LANDSCAPE REVISION RESPONSE

**RE: Claremont Business Park 2 Filing 1, Lot 1
Site Development Plan
File Number PPR2034**

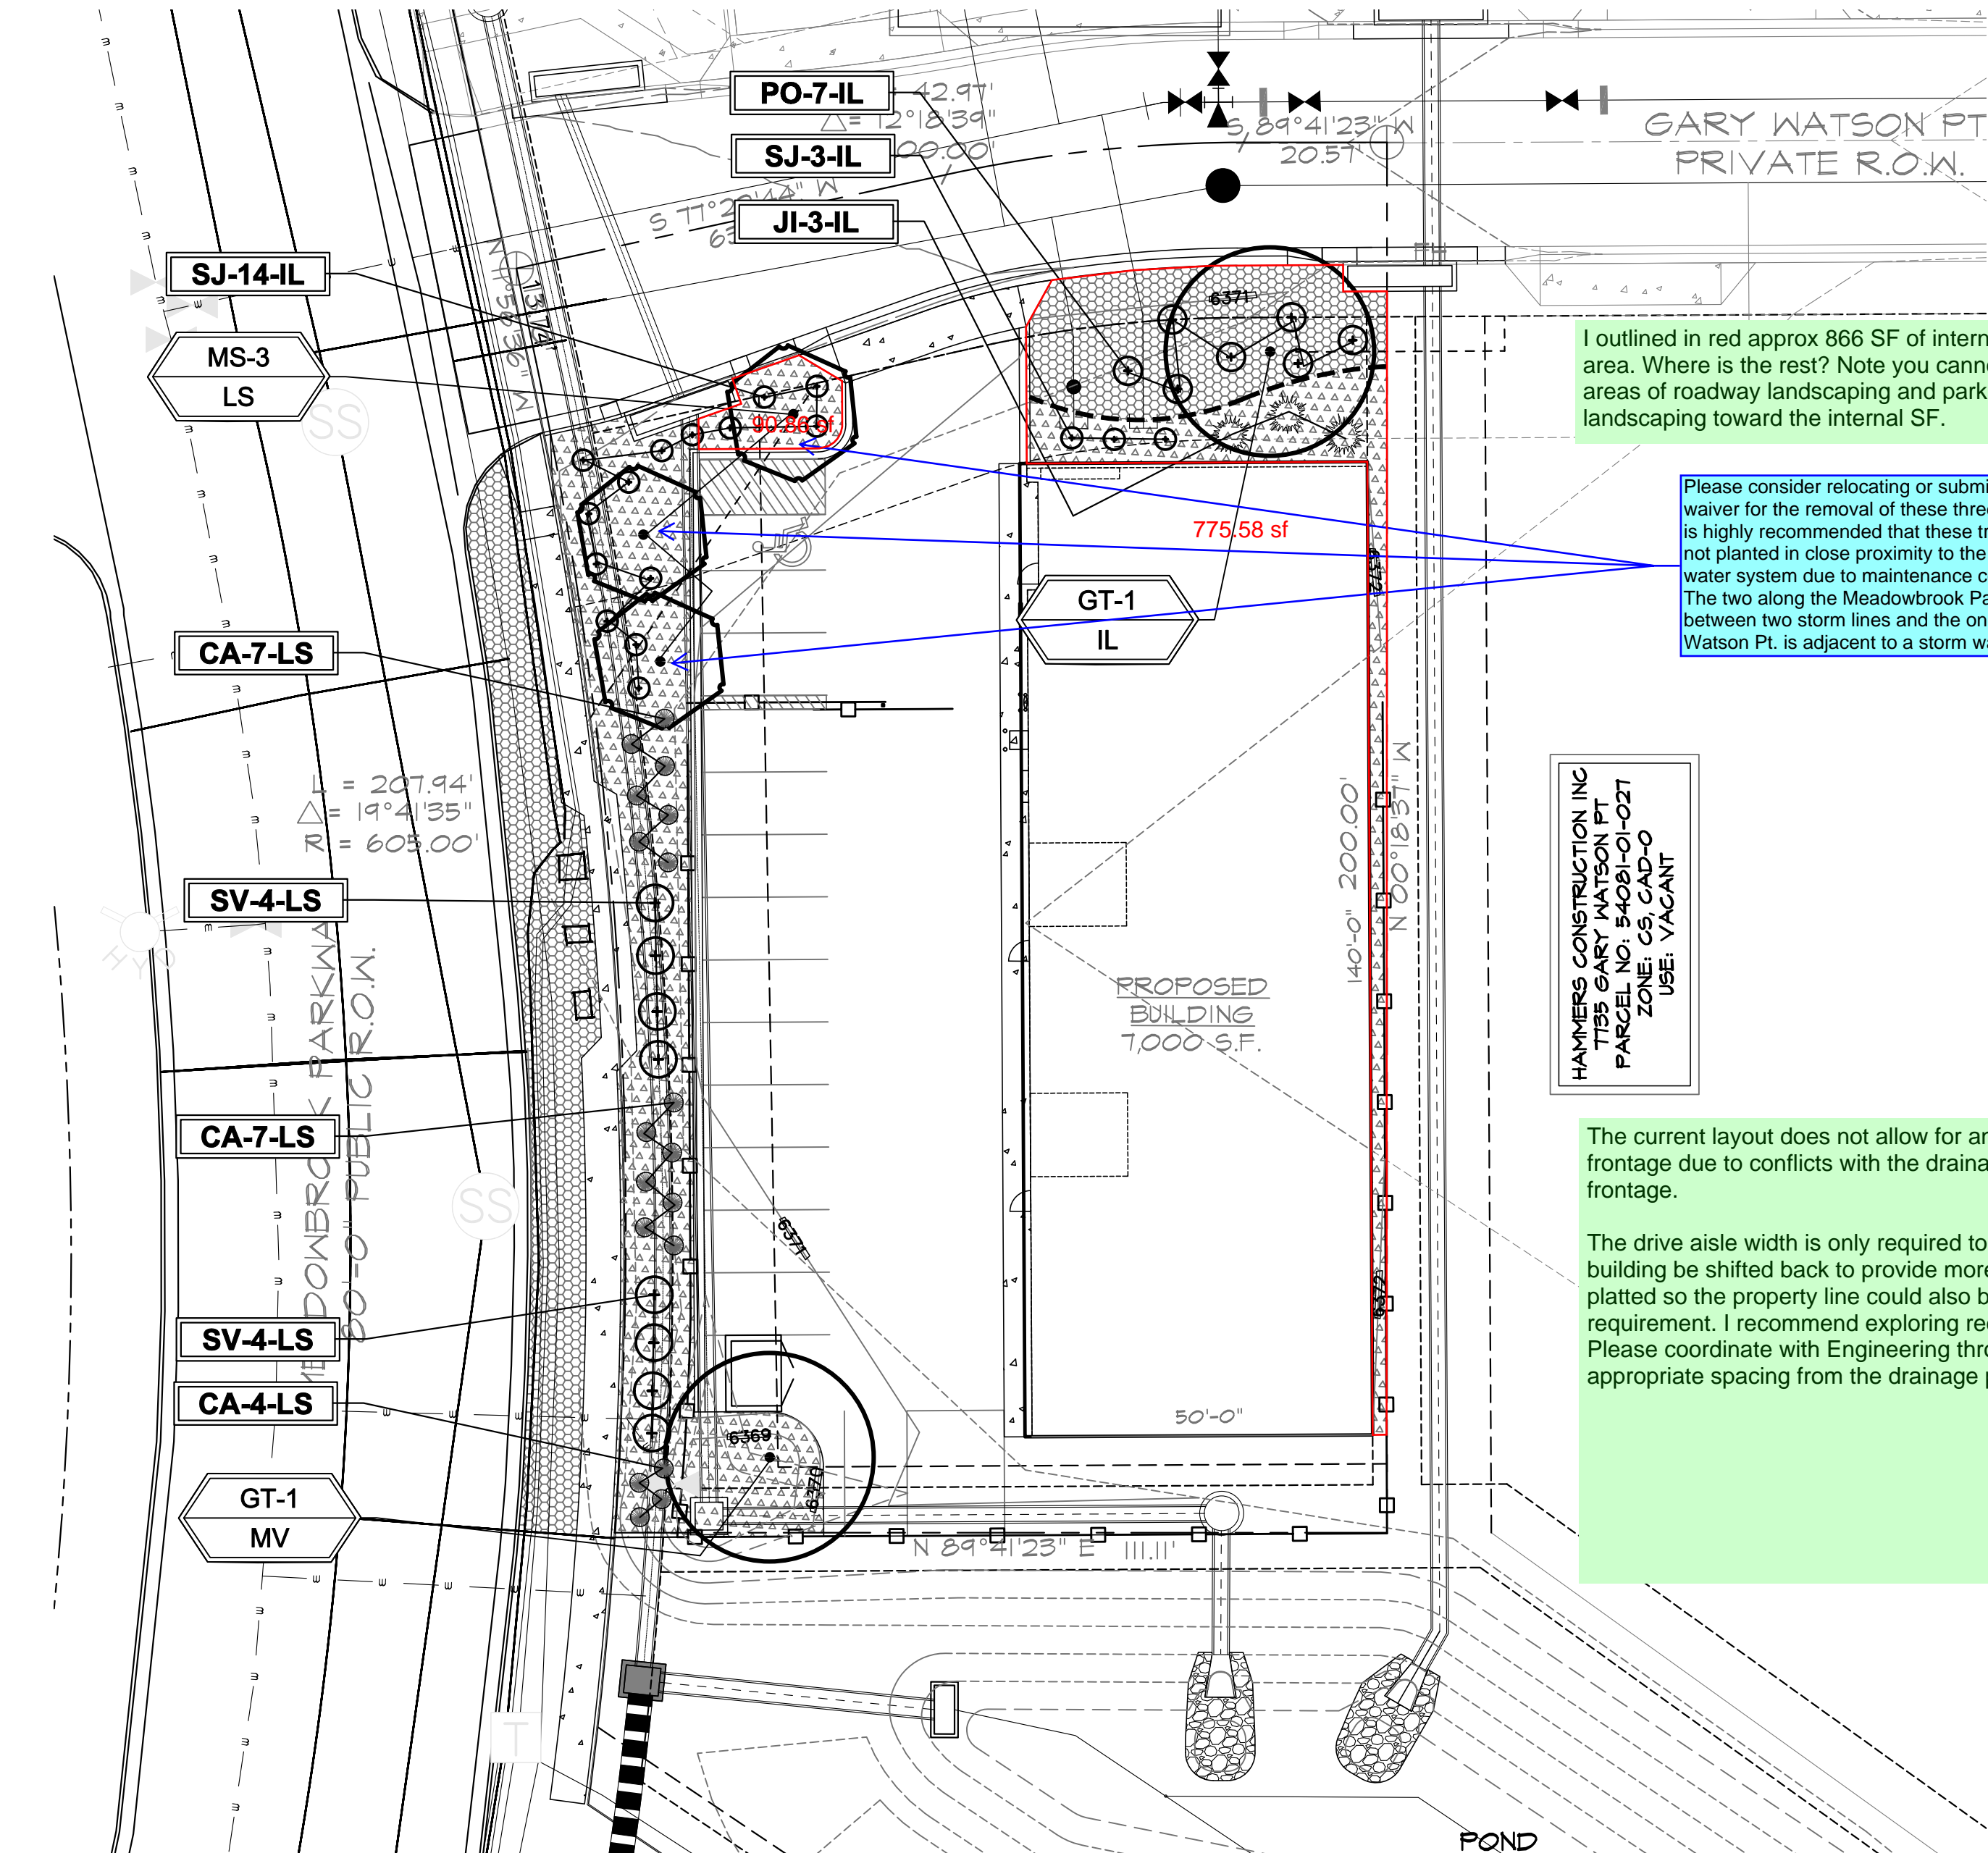
1. 7 landscape trees required along Meadowbrook. Two ornamental and 10 upright evergreen juniper provided. Refer to letter by HGD.
2. Gary Watson is a private drive and landscape trees are not required.
3. Plantings along Meadowbrook for motor vehicle screening adjusted per code and chart updated.
4. Internal landscape provided surrounding building. This area meets minimum code. Area is clouded on plan.
5. Legends and Chart updated accordingly.
